Our Ref: 24/0474/TTCA
Your Ref: Smith

South Cambridgeshire District Council
Application for Works to Trees in a Conservation Area

Proposal: T1 Scots Pine - Dead, Fell.
T2 Multi Stemmed Plane - Remove two lowest limbs from stem over garage and remove four lowest limbs from stem over drive.

Site address: 9 Woodlands Road Great Shelford Cambridgeshire CB22 5LW

GCSP Search-by-Map

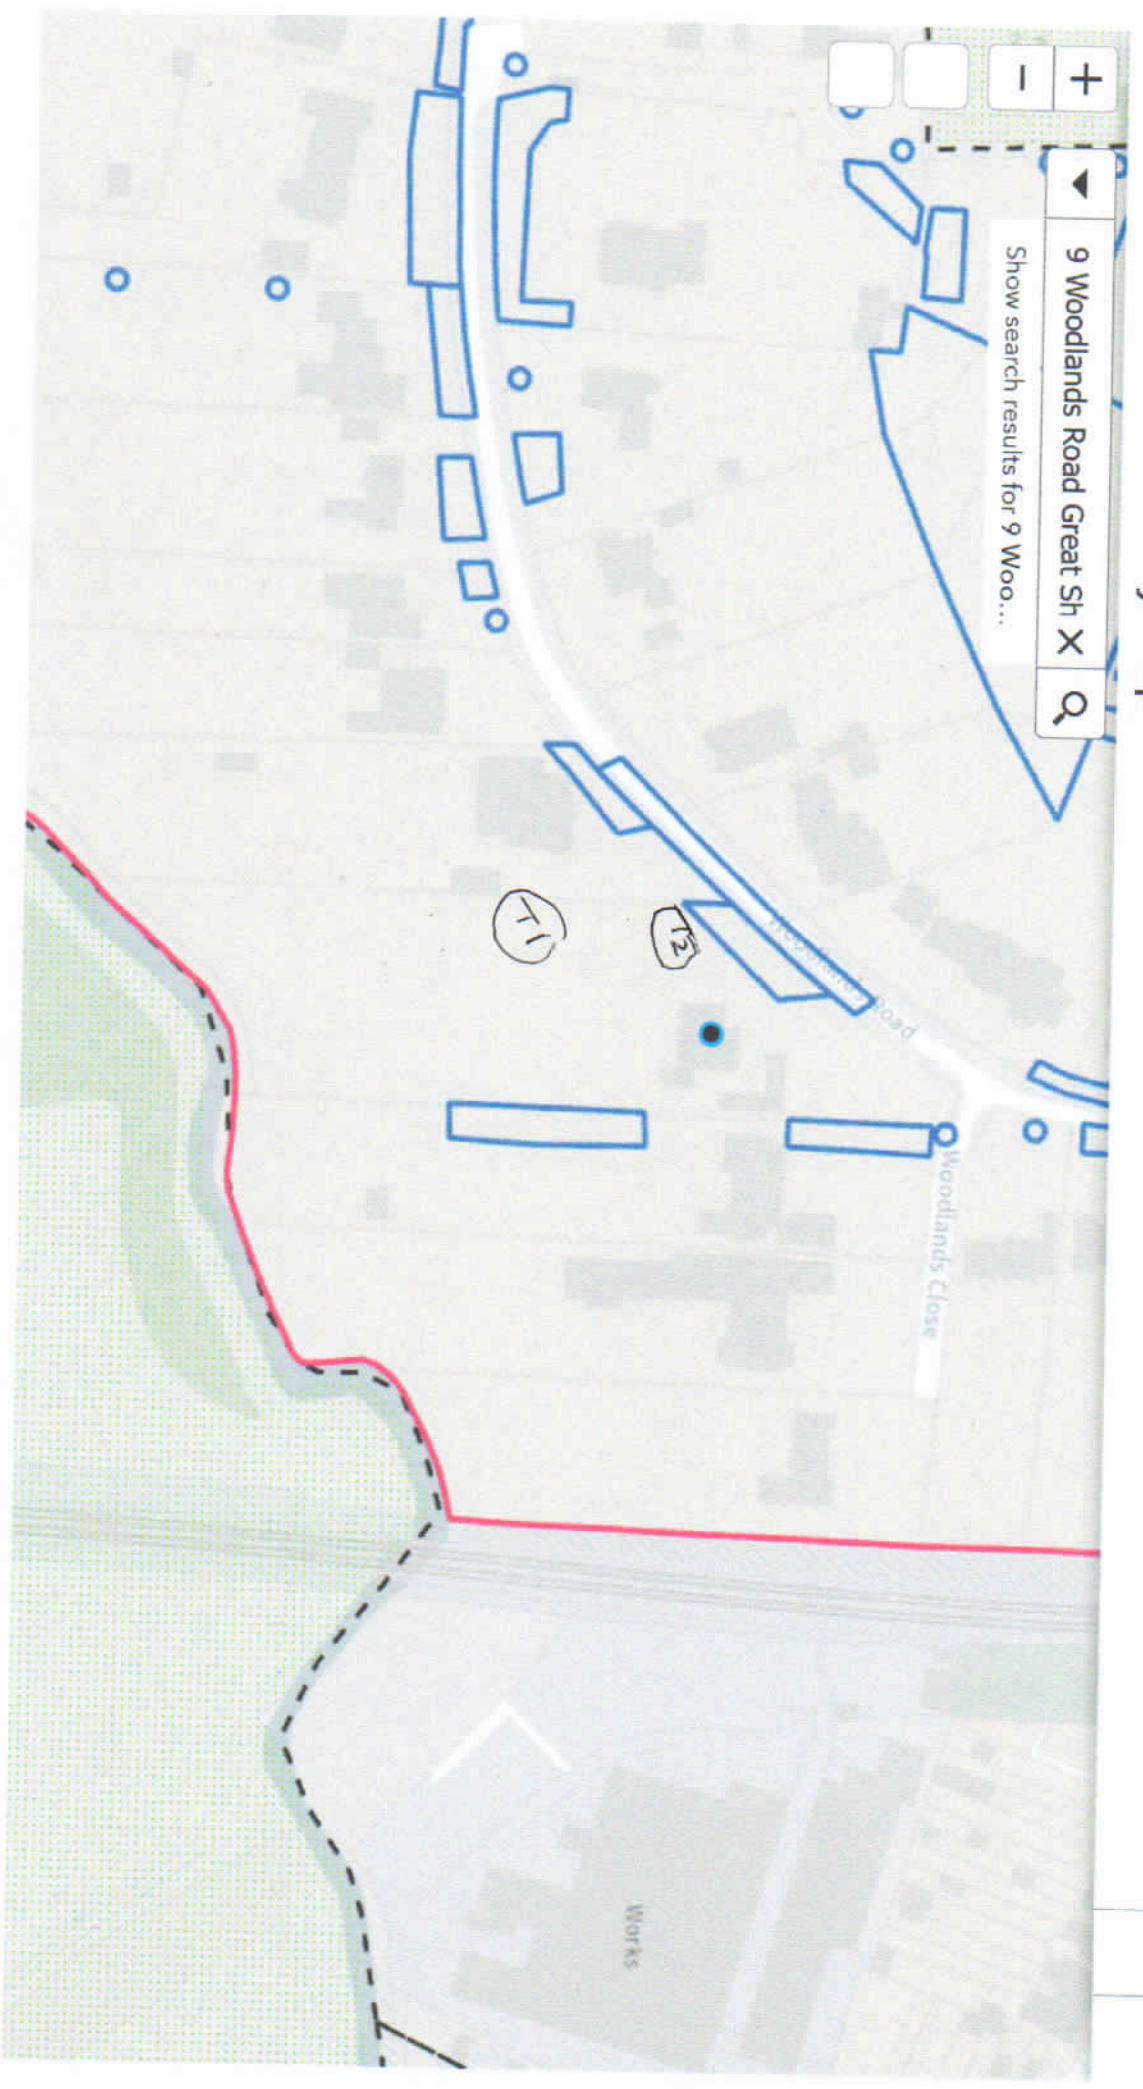
1. The location plan provided shows the trees at the address of 19 Woodlands Road, rather than the given address of 9 Woodlands Road. Please confirm the correct tree address and/or provide a new location plan showing the trees at the correct address.
